Subject: 3/2014/0053 - Demolition of all buildings on site (existing house kennels and various outbuildings) and erection of a new dwelling - The Eaves Pendleton Road Wiswell BB7 9BZ

Planning Application reference : 3/2014/0053

Proposal: Demolition of all buildings on site (existing house kennels and various outbuildings) and erection of a new dwelling.

Location: The Eaves Pendleton Road Wiswell BB7 9BZ

FIRST FLOOR PLAN
4 No Bedrooms

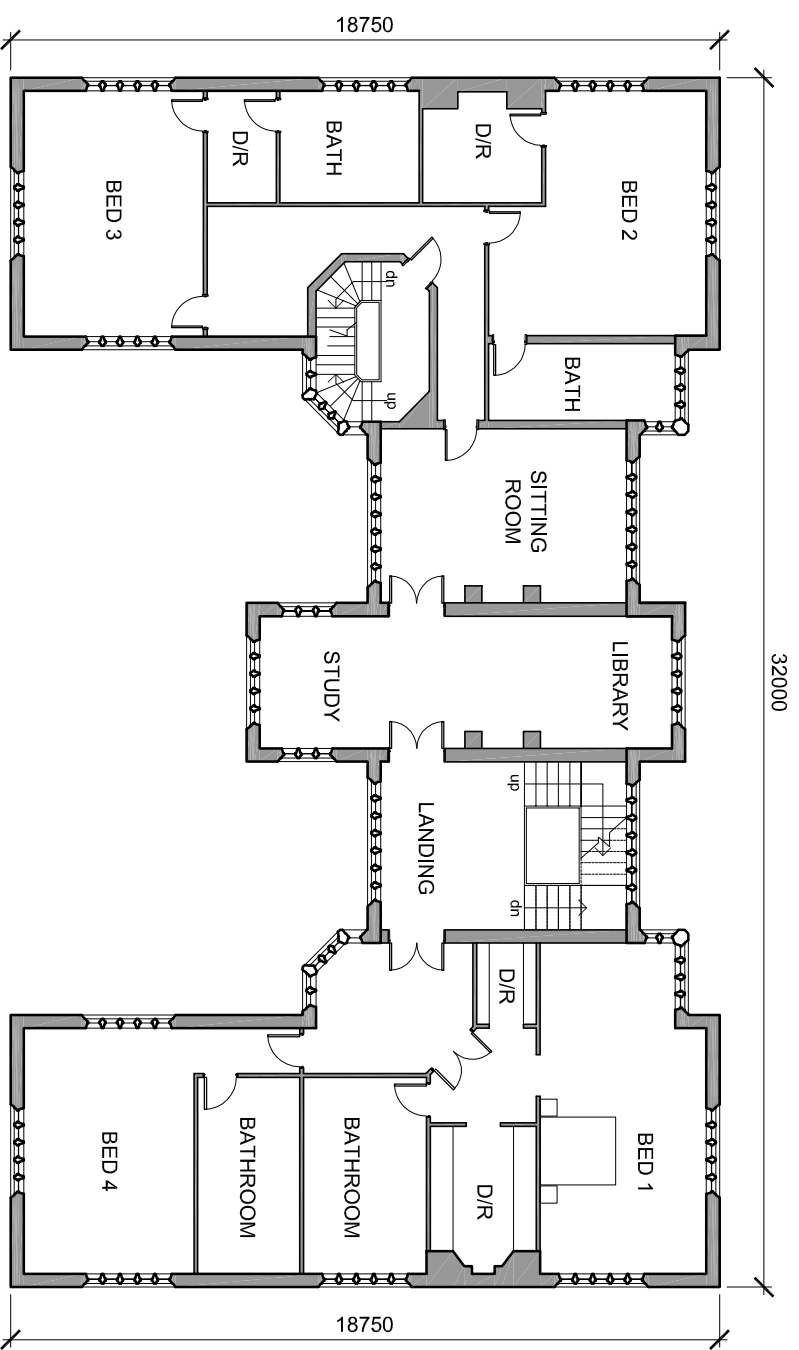
It is noticed from the proposed layout plan that there will be total 7no bedrooms to use within the dwelling including 2no for bed and breakfast business. According to JLSP residential parking requirements 4+ bedroom house will require 3no parking spaces within curtilage of the property. It is noticed that three parking spaces are the provided in the basement to accommodate vehicles associated with the residential use. Three additional parking spaces on the ground floor is provided which may serve the purpose for the B & B business. Thus there are total of 6no parking spaces for the residential use as well as for the B & B business. This is considered sufficient with regard to the proposed use of the building. There is a slight ambiguity with regards to the parking spaces. Application form indicates 11no parking spaces where as proposed layout plan shows 6no parking spaces (3no in basement and 3no on ground floor). Nevertheless 6no parking spaces suffice the current requirement of off road parking spaces.

With the above considerations, it is believed that proposed development is unlikely to have a significant effect on to the adjacent highway network. There is no objection to the proposed development on highway grounds.
